**Addendum No. 1**

RE: Contract ID C202822

**Johnston County (B-4555)**

Bridge Over Norfolk Southern Railway and Approaches on US-70

**BENT #1
SECTION A-A**

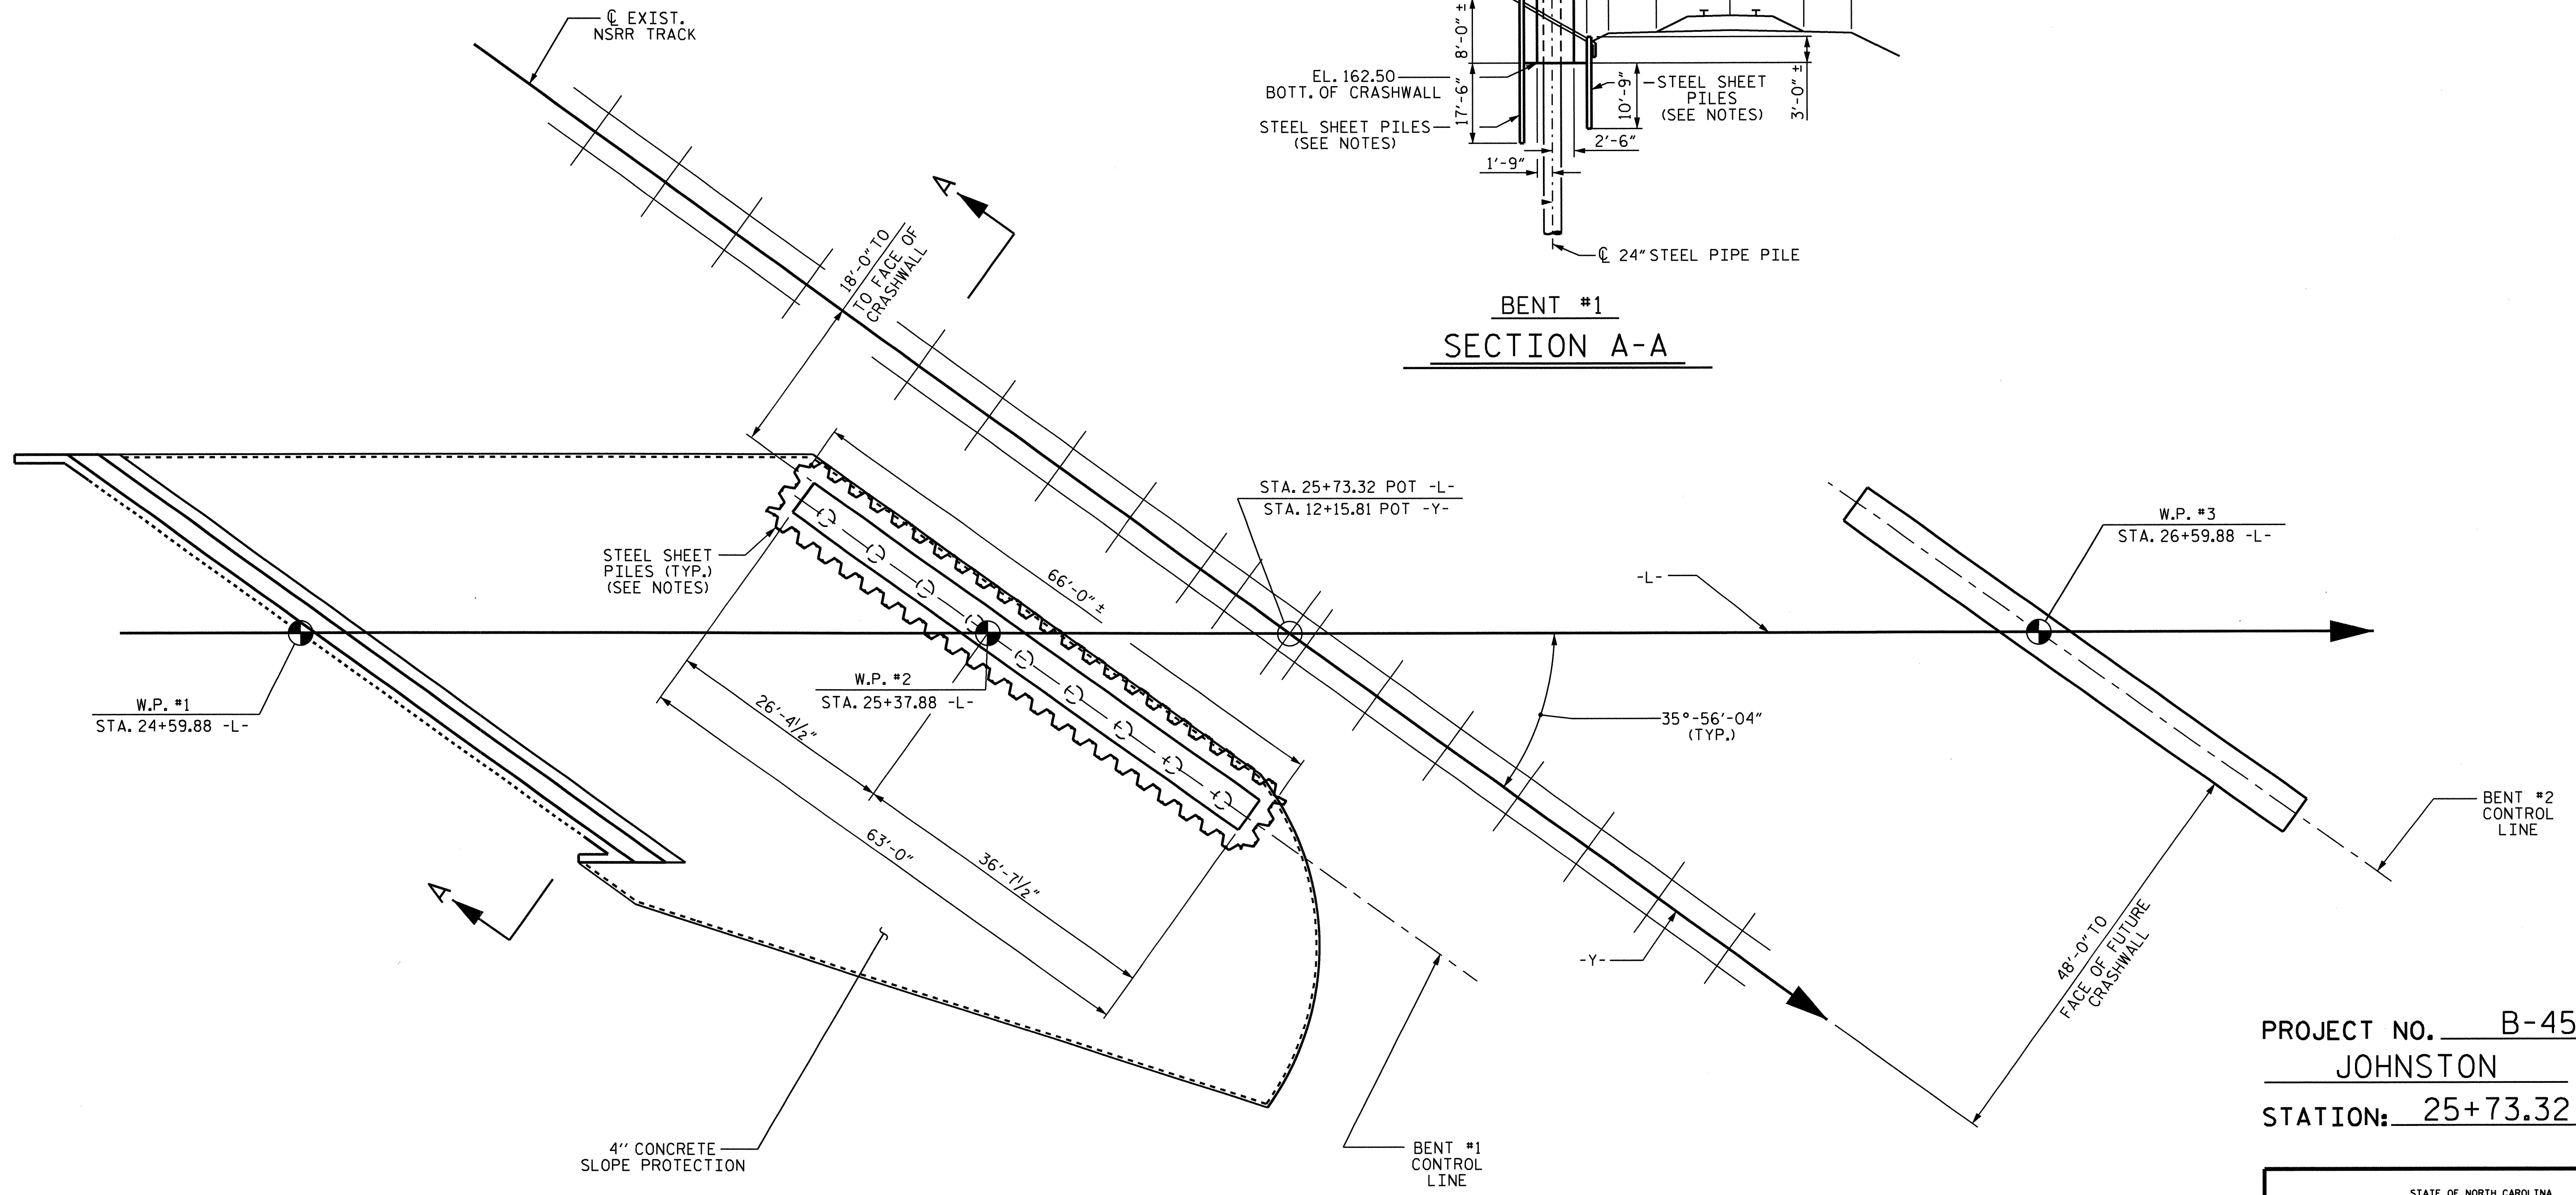
Sheet Nos. S-1, S-3, S-27 thru S-29 have been revised to add a crash wall at Bent No. 2. Please void Sheet Nos. S-1, S-3, S-27 thru S-29 in your plans and staple the revised Sheet Nos. S-1, S-3, S-27 thru S-29 thereto.

DESIGN TEMPORARY SHORING FROM STATION 26+00, 20.3 FT. TO 29.9 FT. LEFT OF -L- TO STATION 27+35, 20.3 FT. TO 29.9 FT. LEFT OF -L- FOR THE FOLLOWING ASSUMED SOIL PARAMETERS AND GROUNDWATER ELEVATION:

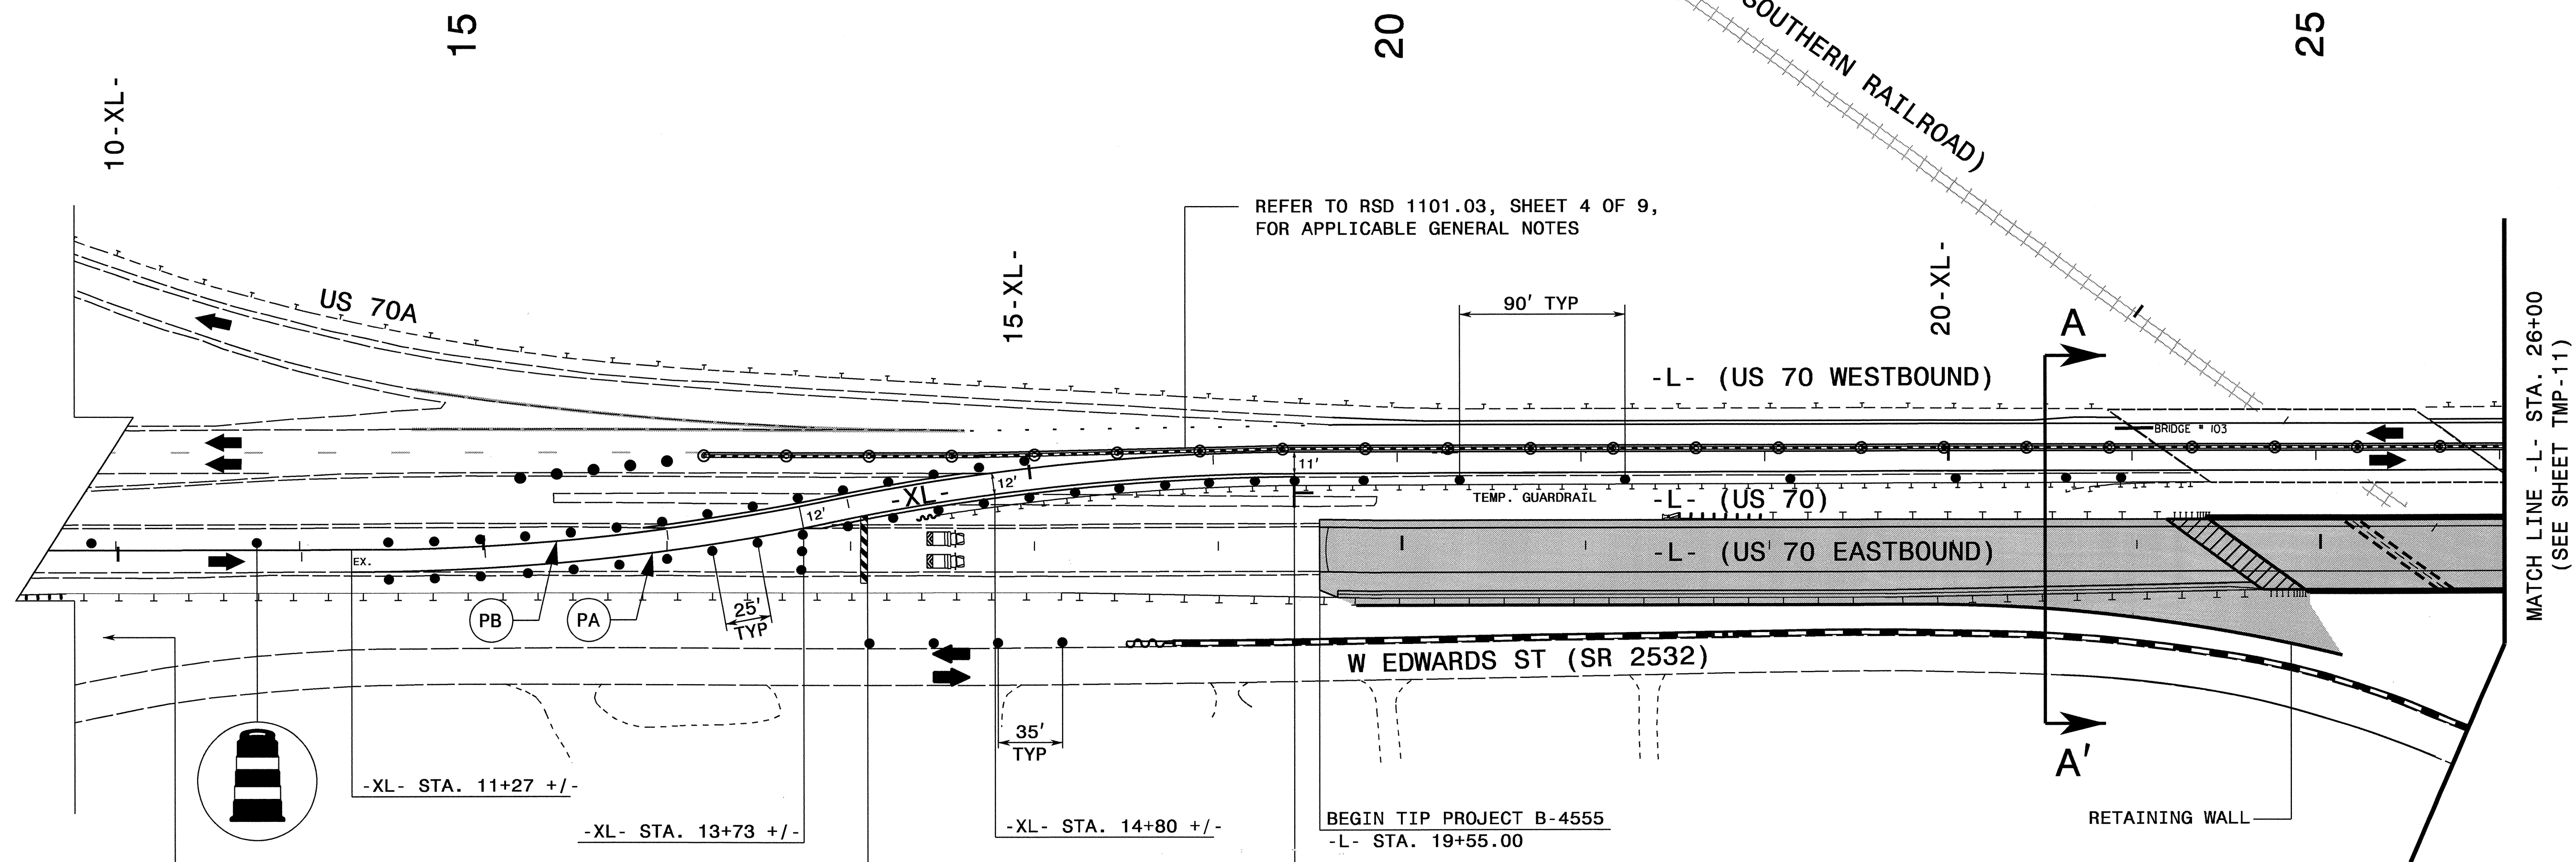
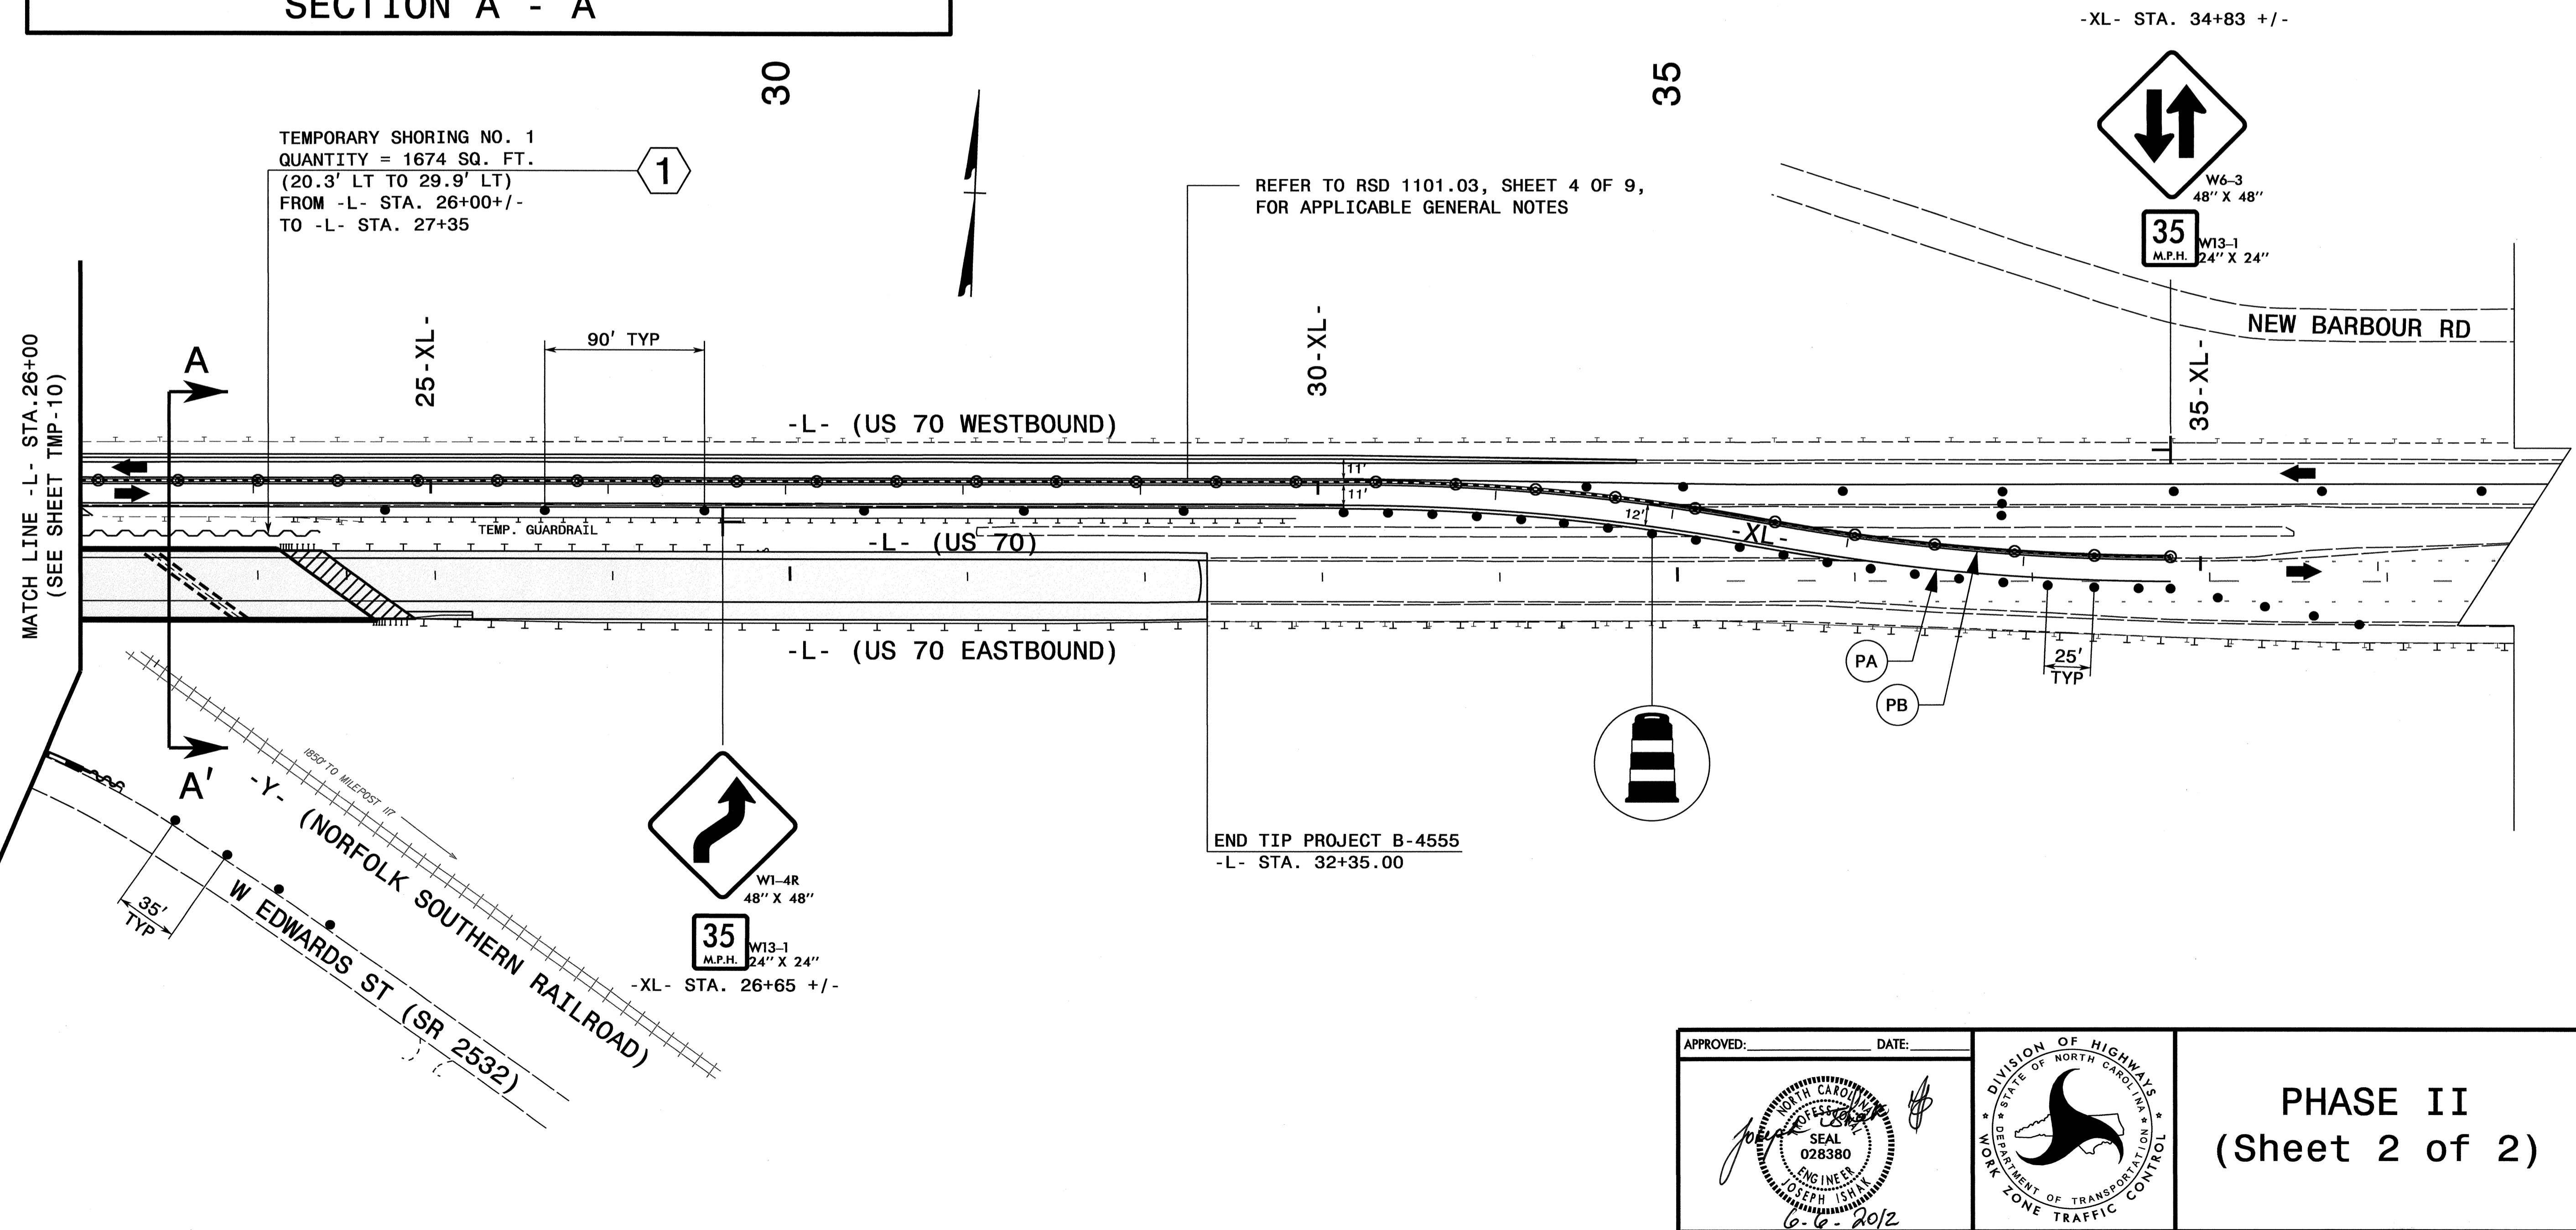
Sheet No. TMP-11 has been revised to add "Temporary Shoring". Please void Sheet No. TMP-11 in your plans and staple the revised Sheet No. TMP-11 thereto.
